Cockle Bay Park – Response to Agency Submissions

7.12 Temperature – after 100 minutes

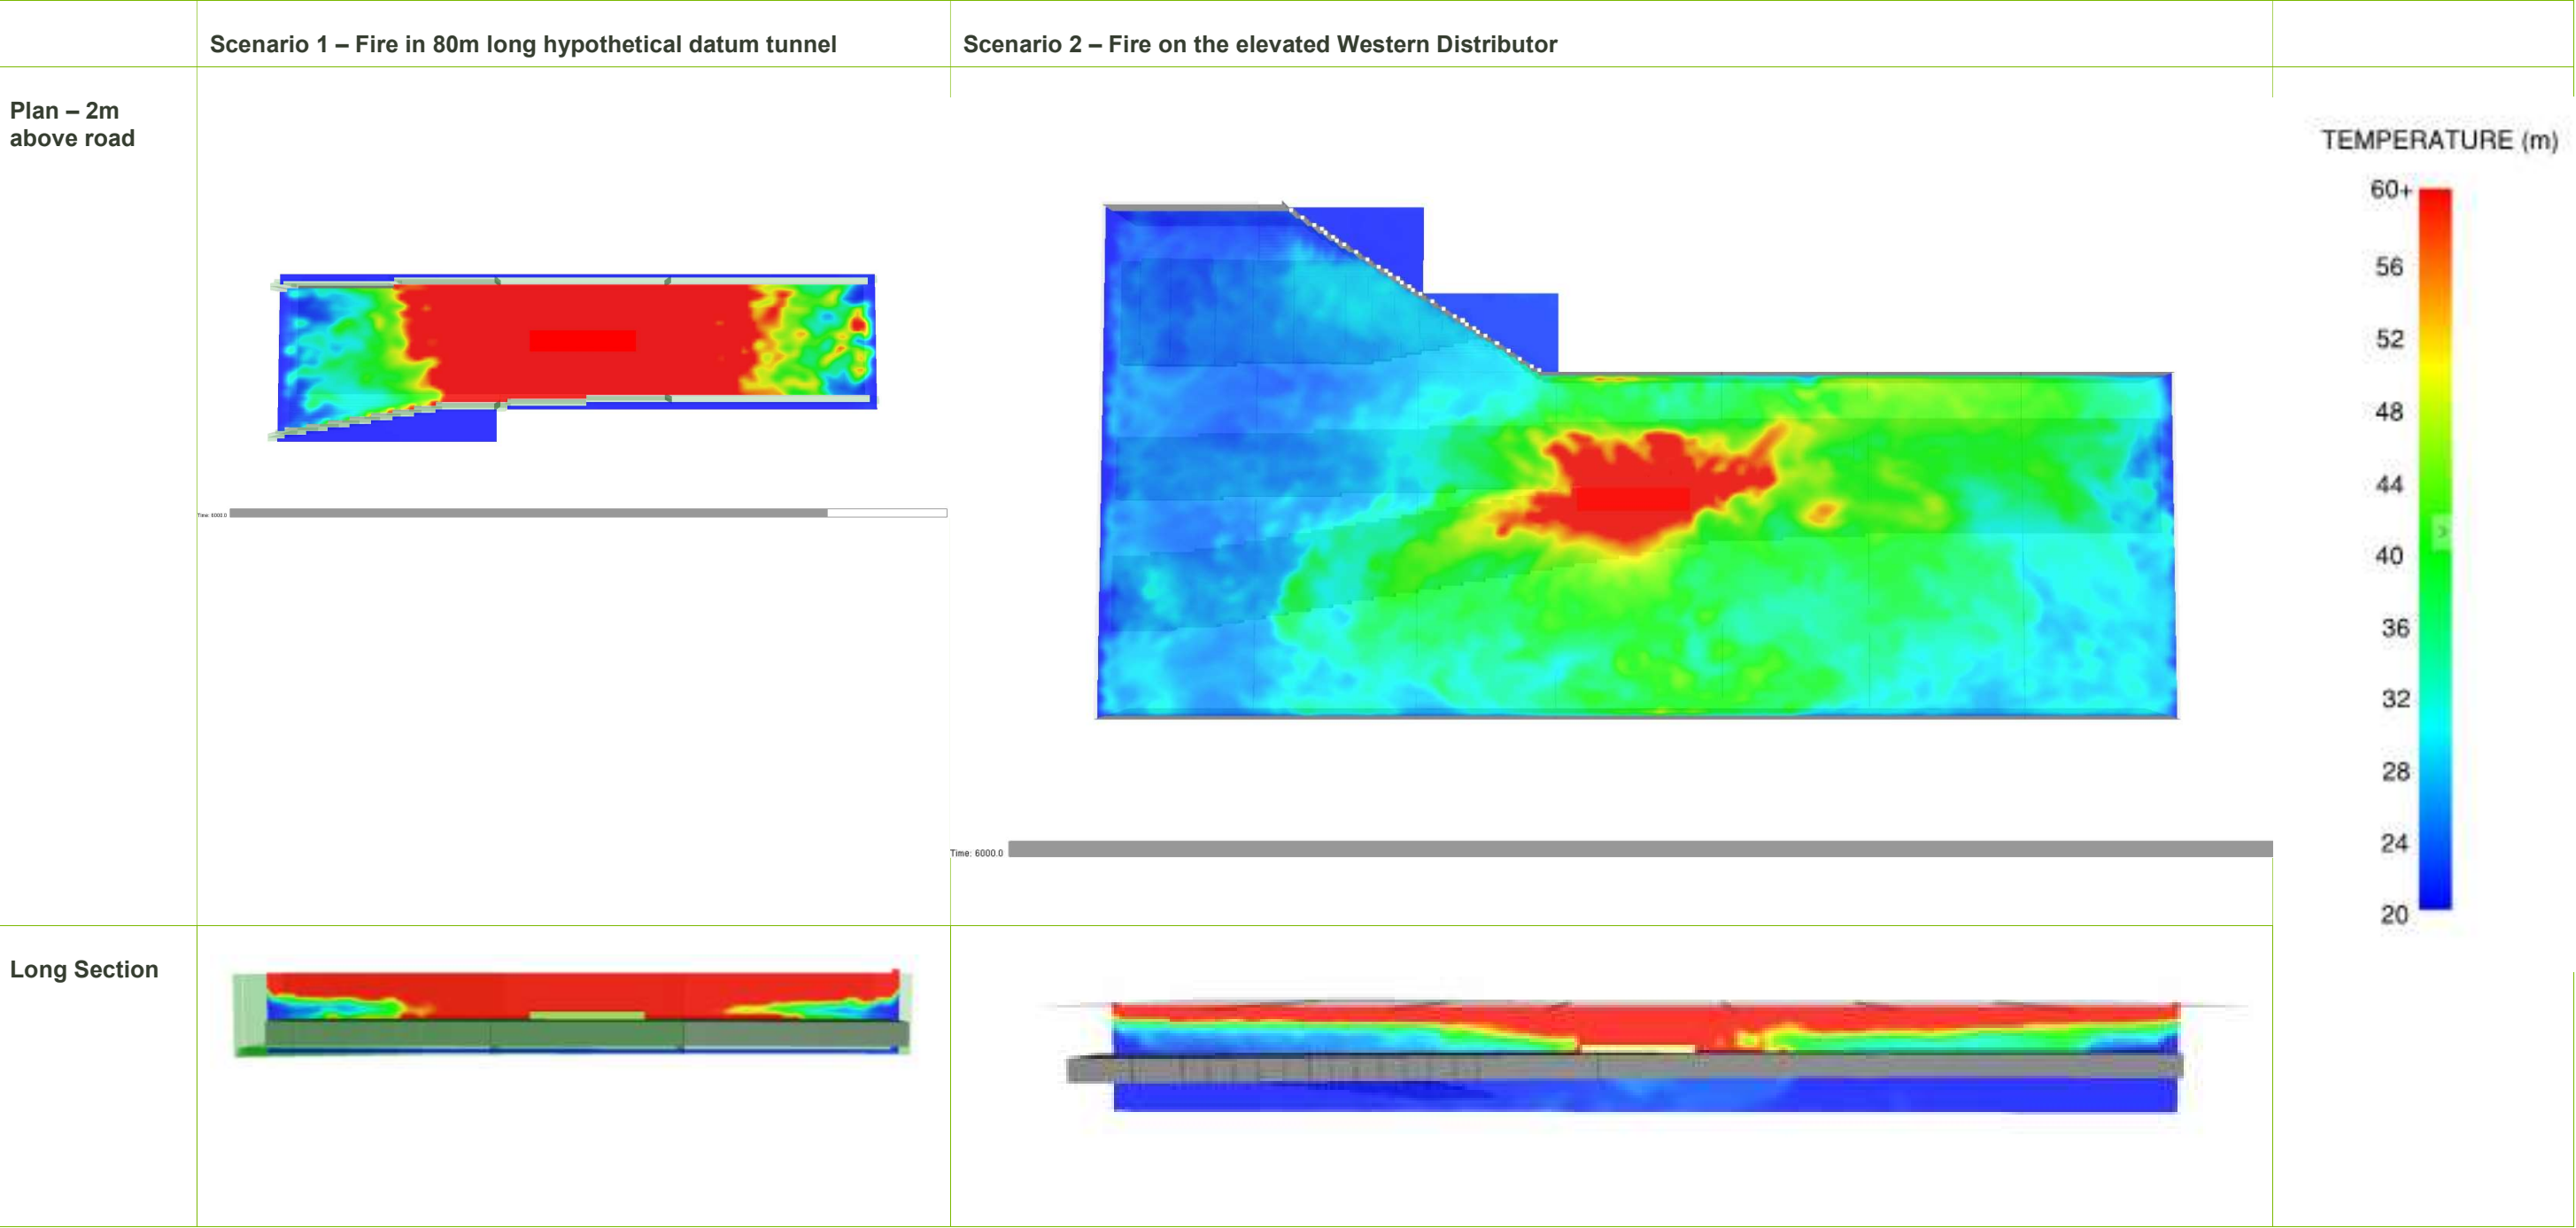
<p>Fire safety – the proposal has the effect of creating a tunnel underneath the podium – adequate provision of fire safety must be provided regarding traffic flow</p>	<p>Fire safety design criteria regarding the Western Distributor as it travels under the landbridge have been developed by Aurecon, in consultation with RMS (refer to Appendix J1). The design criteria are to be implemented at the relevant future stages of detailed design to ensure adequate fire safety provision is achieved.</p>
<p>Piering Options – RMS has request no piers in addition to the proposed piers option</p>	<p>Enstruct and Aurecon have considered structural options for landbridge pier locations including piers between on-grade northbound Harbour St and the elevated Western Distributor and an alternate 'no piers' option. The options are presented at Appendix K and Appendix W (refer to Section 7.20 of the</p>

ENVELOPE PLAN - GROUND LEVEL

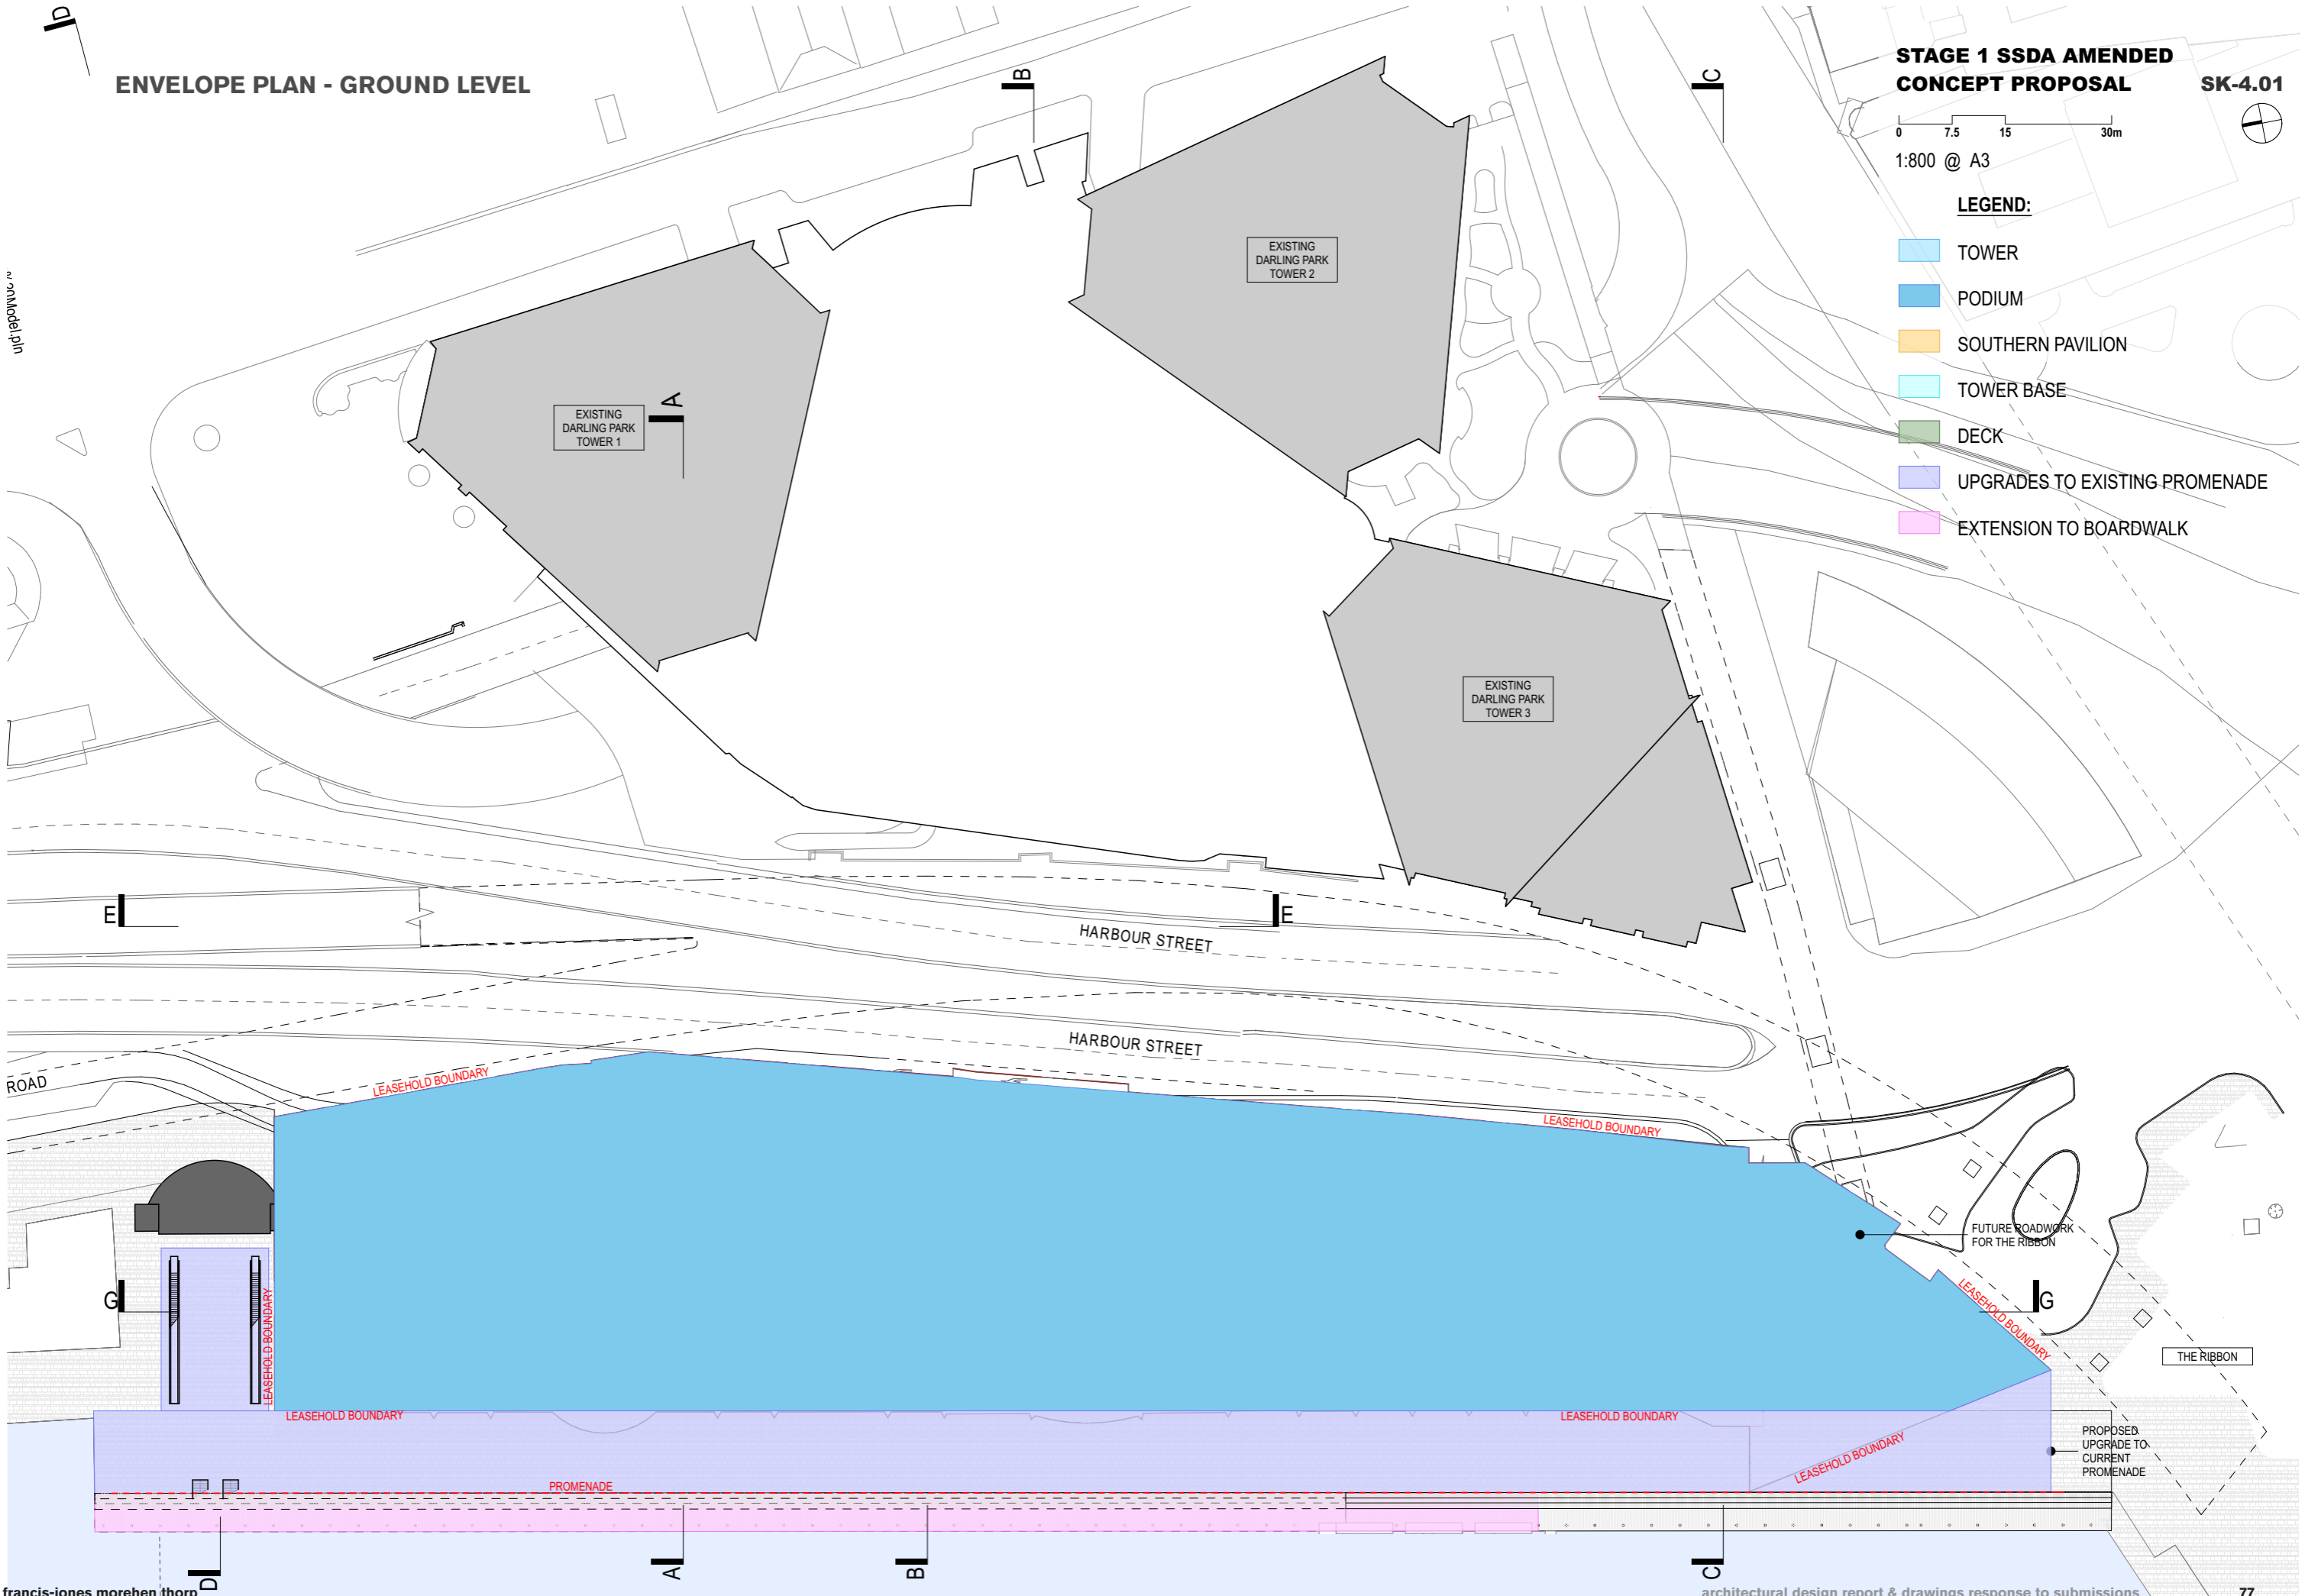
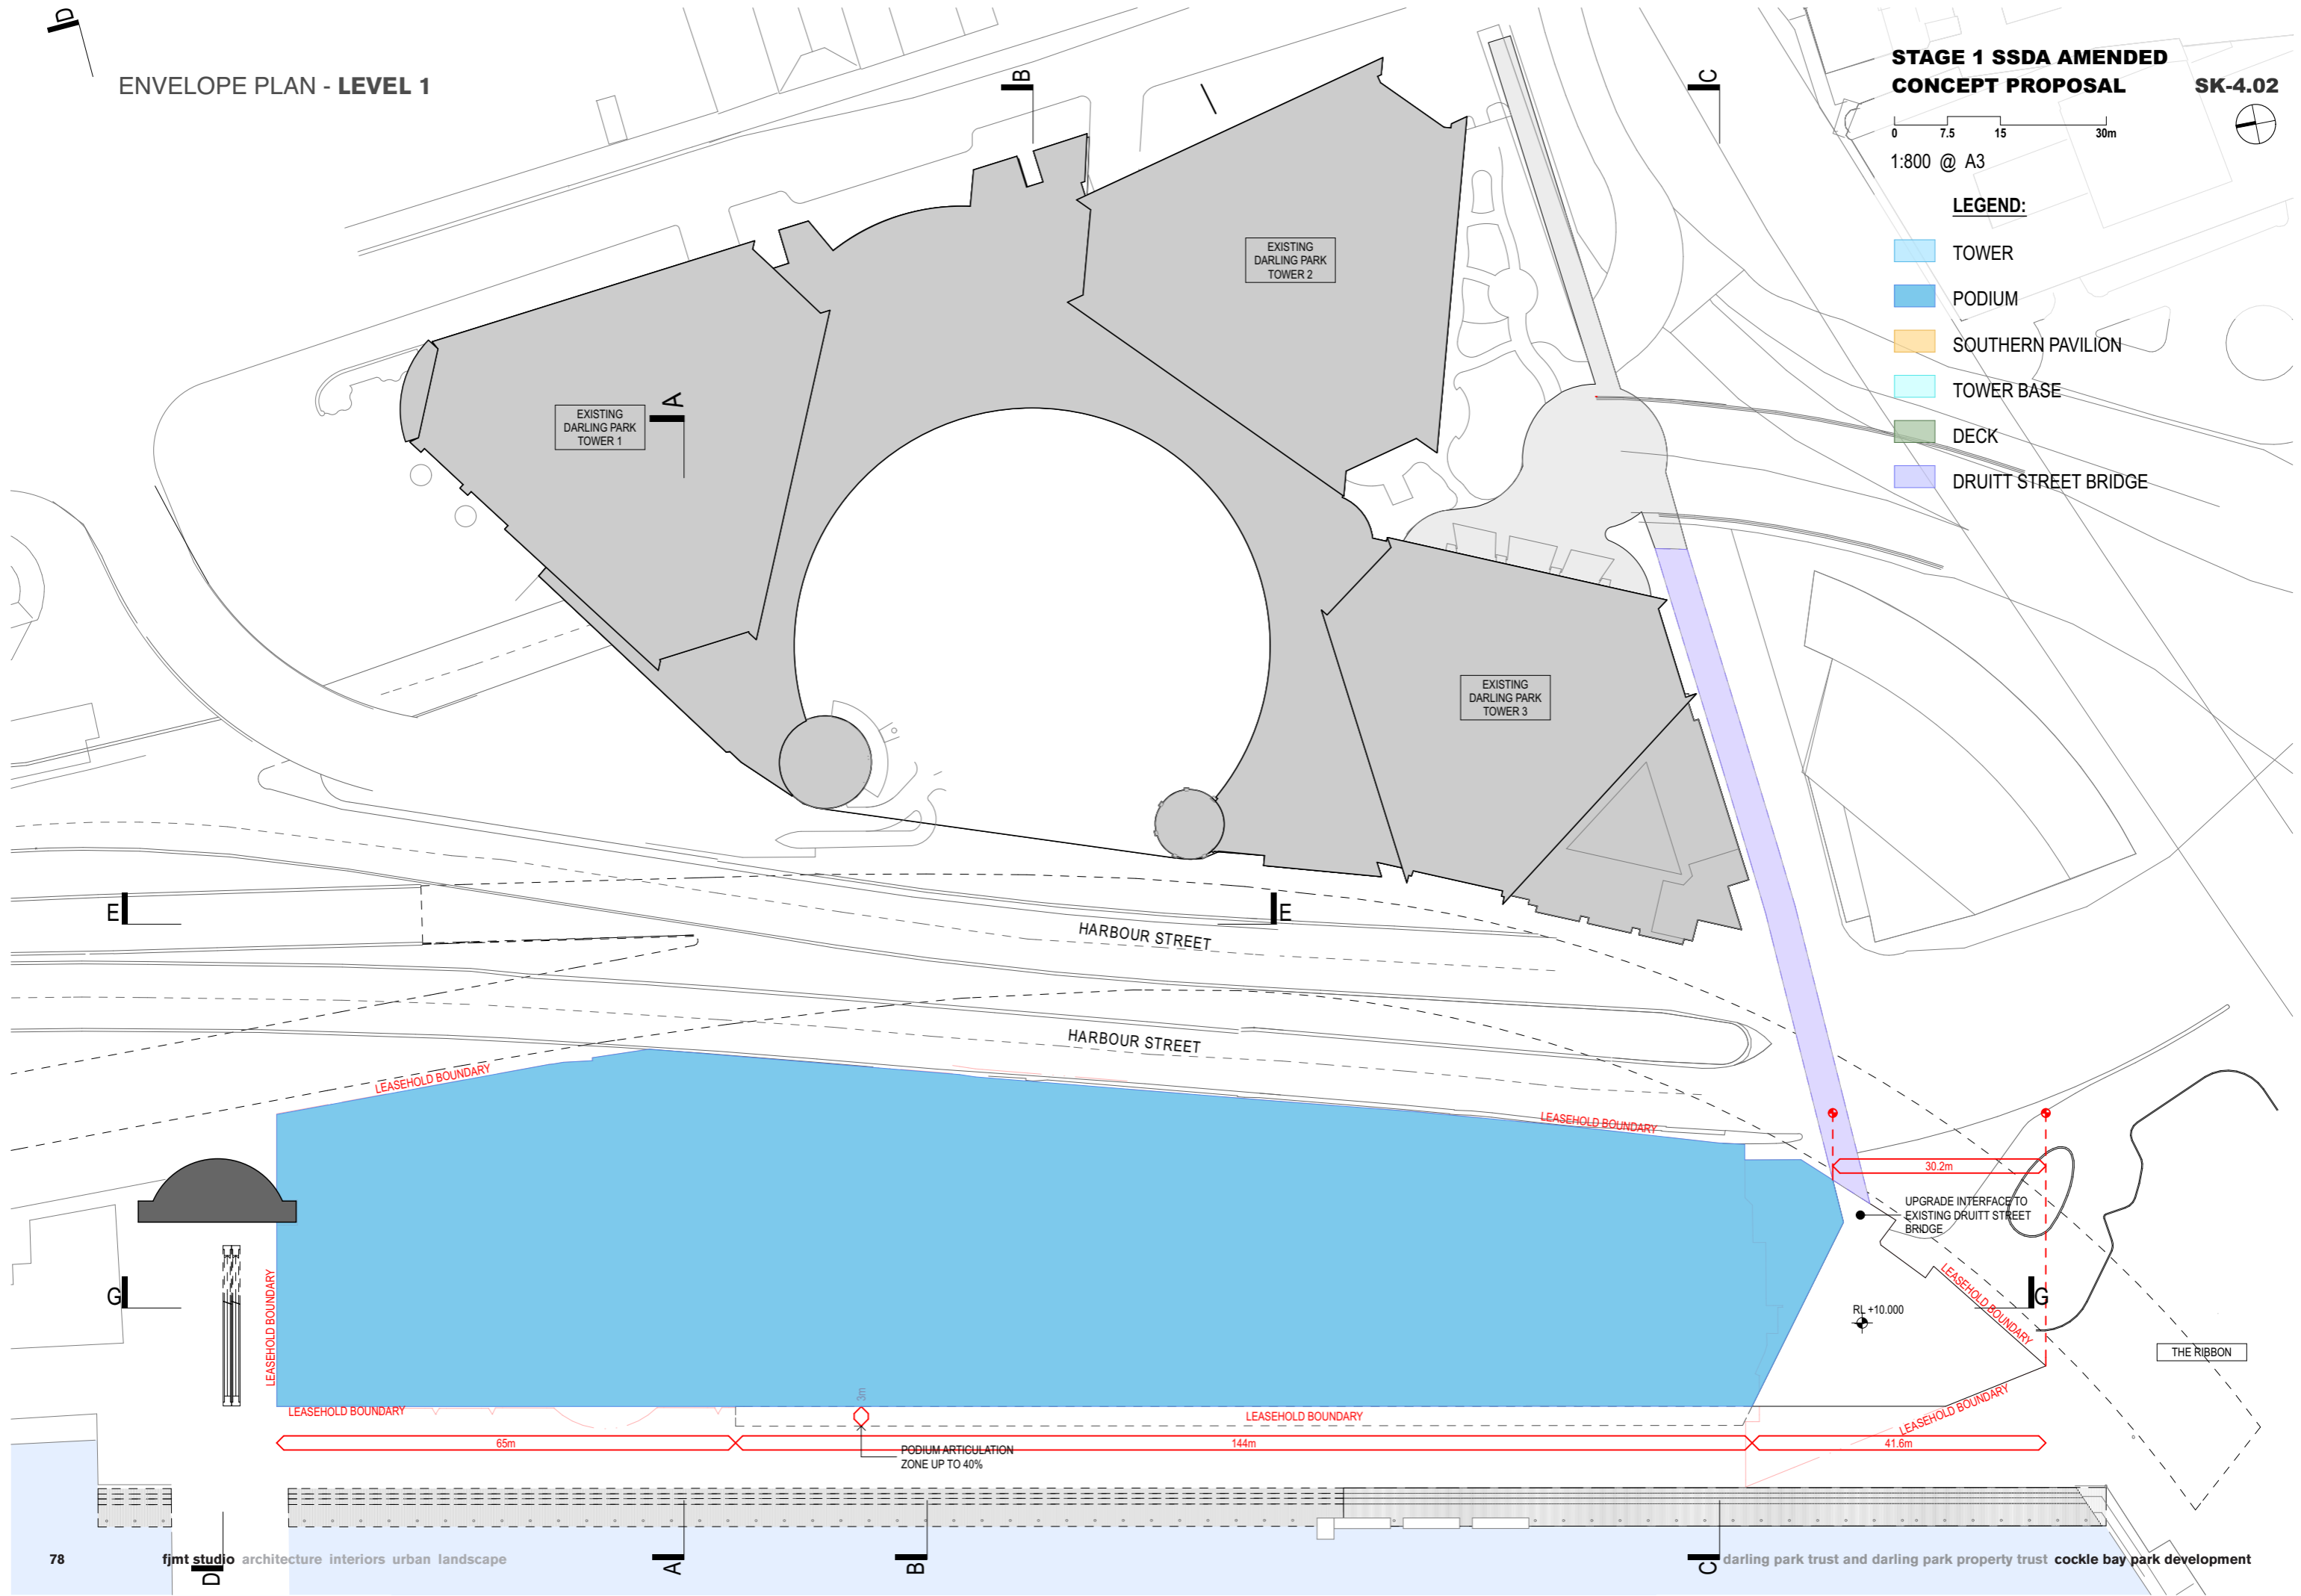
<p>The excessive bulk and scale of the proposal – the height and floor plate of the proposed commercial tower element;</p>	<p>The Concept Proposal has been amended since the exhibition of the EIS including:</p> <ul style="list-style-type: none"> • a 40 metre (17 percent) reduction in the height of the tower from RL235m to RL195m; • reduction in commercial GFA by 10,000m² (12 percent); • a reduction in retail GFA from 25,000m² to 14,000m² (44 percent); • reduction in the tower envelope footprint from 3,890m² to 3,575m² (8 percent); and

Item Raised	Proponent's Response
	<ul style="list-style-type: none"> the overall volume of the envelope has reduced by 153,000m³ (15.65 percent). <p>The amended Concept Proposal provides a proportional relationship to the existing buildings of Darling Park in consideration of height, separation and breadth so the precinct can be read as a whole. Building height and scale is further discussed at Section 7.6 and in the Architectural Design Report at Appendix C.</p>
<p>The bulk and massing of the podium and the relationship with the public domain, Pyrmont Bridge;</p>	<p>It is noted that the height of the existing Cockle Bay Wharf building is approximately RL19m, which is equal to the proposed height of the podium deck envelope. Accordingly the proposed podium at Level 3 will be of a similar scale to the existing development on Site which is considered acceptable.</p> <p>The amended Concept Proposal has revised the bulk and massing of the podium envelope to strengthen its relationship to the public domain and Pyrmont Bridge. This has been achieved through the following amendments:</p> <ul style="list-style-type: none"> reduce the volume of the Southern pavilion by reducing the height from RL31m to RL29m with the introduction of a minimum setback of between 8.5m and 9.5m from the lease boundary; increase the setback to the southern side of Pyrmont Bridge from 2m to 65m at Level 2 of the Podium; provide a new 44m (east-west) separation between the northern podium envelope (above Level 1) and the waterfront; reduce the length of the podium articulation zone along the foreshore from 209 m to 144 m, reducing the overall podium volume; include provision to extend the boardwalk (5m wide) which would further increase the spatial relationship between the podium and waterfront; and consolidate publicly accessible open space adjacent to Pyrmont Bridge. <p>The amended Concept Proposal will elevate the significance of the public domain by knitting the Site</p>
